From: Jameson, Patricia [Patricia.Jameson@uuplc.co.uk]
Sent: 10 September 2012 15:28
To: planning
Subject: 3/20/0738

Your ref: 3/2012/0738
Our ref: DC/12/3699
Date: 10-SEP-12

With reference to the above planning application

no: Existing & proposed site & location plans

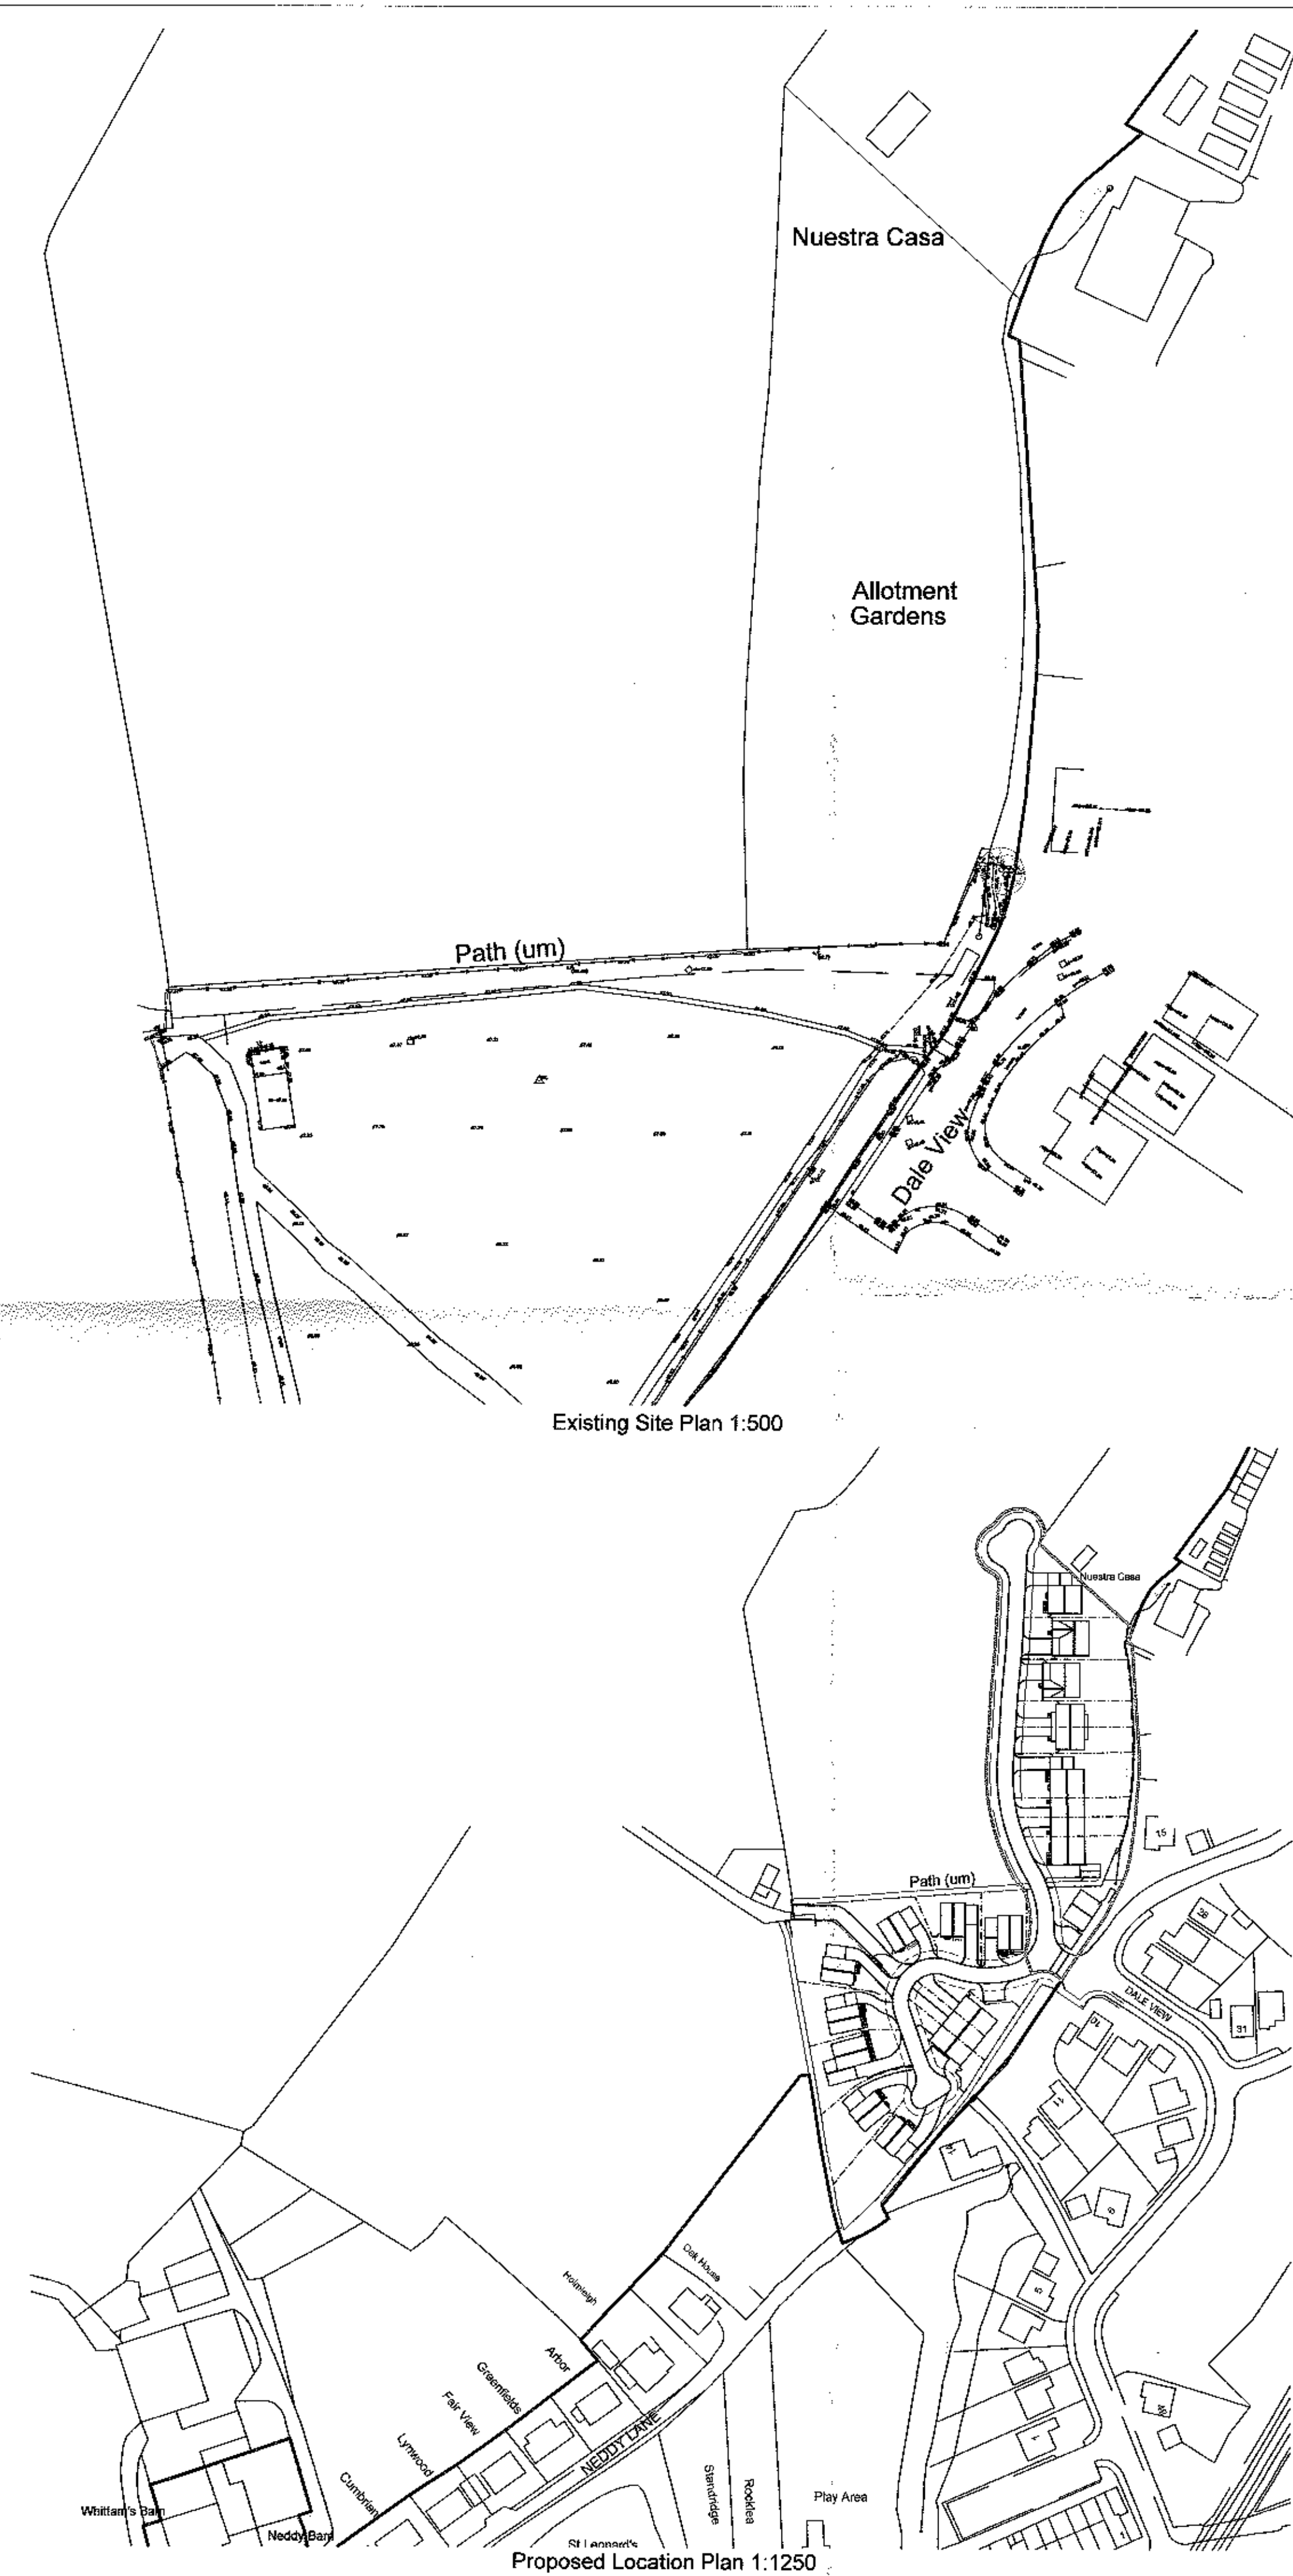
- A public sewer crosses this site and we will not permit building over it. We will require an access strip width of 6 metres, 3metres either side of the centre line of the sewer which is in accordance with the minimum distances specified in the current issue of "Sewers for Adoption", for maintenance or replacement

- This site must be drained on a separate system, with only foul drainage connected into the combined sewer. Surface water should discharge to the soakaway watercourse which may require the consent of the Local Authority. If surface water is allowed to be discharged to the public surface water sewerage system we will require the flow to be attenuated to a maximum discharge rate of 5 l/s

- In accordance with Technical Guidance for National Planning Policy Framework (NPPF), surface water should not be allowed to discharge to foul/combined sewer as stated in the planning application. This prevents foul flooding and pollution of the environment
